Charlotte Storm Water  
600 East Fourth Street  
Charlotte, N C 28202-2844

## Rezoning Petition Review

**Rezoning Petition #:** 20-165

RZ1.00

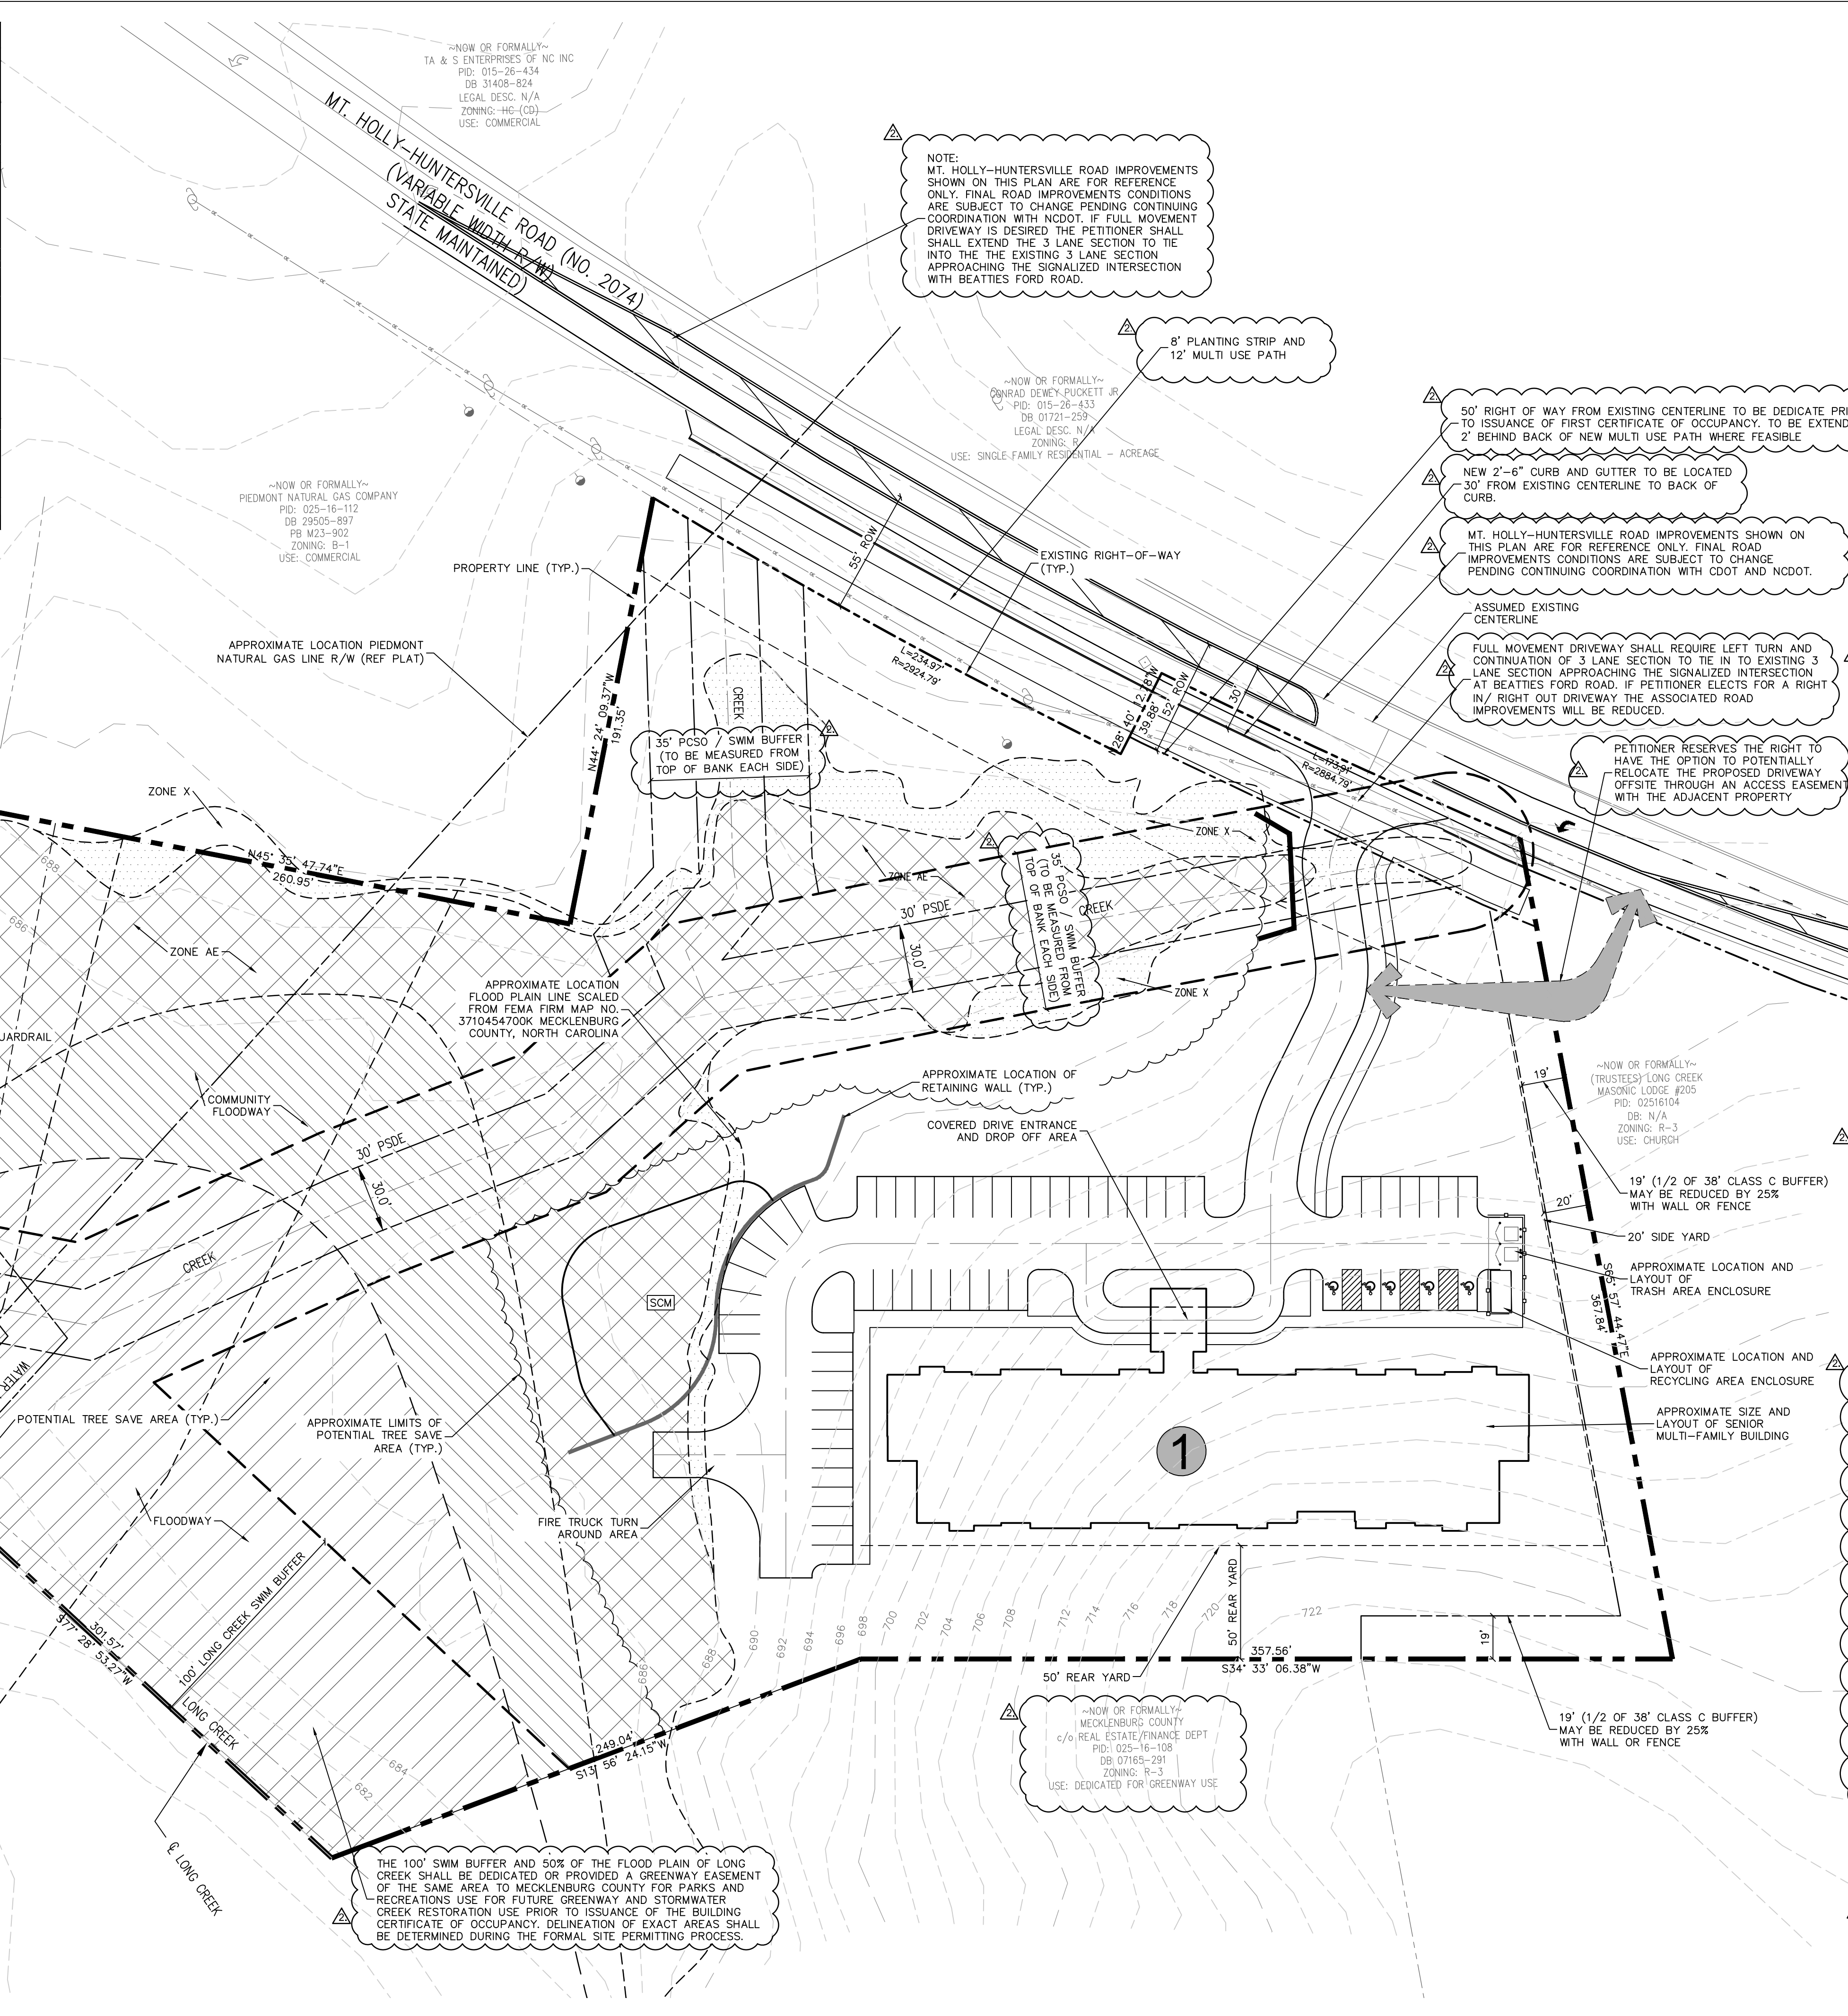
City of Charlotte GIS indicates two 35-ft PCSO/SWIM Buffers on site but only one is shown on sheet RZ-1. Please add the second potential buffer to the plan sheet.

Please revise "70' SWIM Buffer" to read "35-ft PCSO/SWIM Buffer". Note to petitioner: PCSO/SWIM buffer widths are measured from the surveyed/located top of bank and outward from each top of bank.

Please include the following notes on the plan sheet:

- The petitioner shall comply with the Charlotte City Council approved and adopted Post Construction Stormwater Ordinance. The location, size, and type of storm water management systems depicted on the Rezoning Plan are subject to review and approval as part of the full development plan submittal and are not implicitly approved with this rezoning. Adjustments may be necessary in order to accommodate actual storm water treatment requirements and natural site discharge points.
- Development within any SWIM/PCSO Buffer shall be coordinated with and subject to approval by Charlotte-Mecklenburg Storm Water Services and mitigated if required by City ordinance. Petitioner acknowledges intermittent/perennial stream delineation reports are subject to review and approval upon submission of development plans for permitting and are not approved with rezoning decisions.
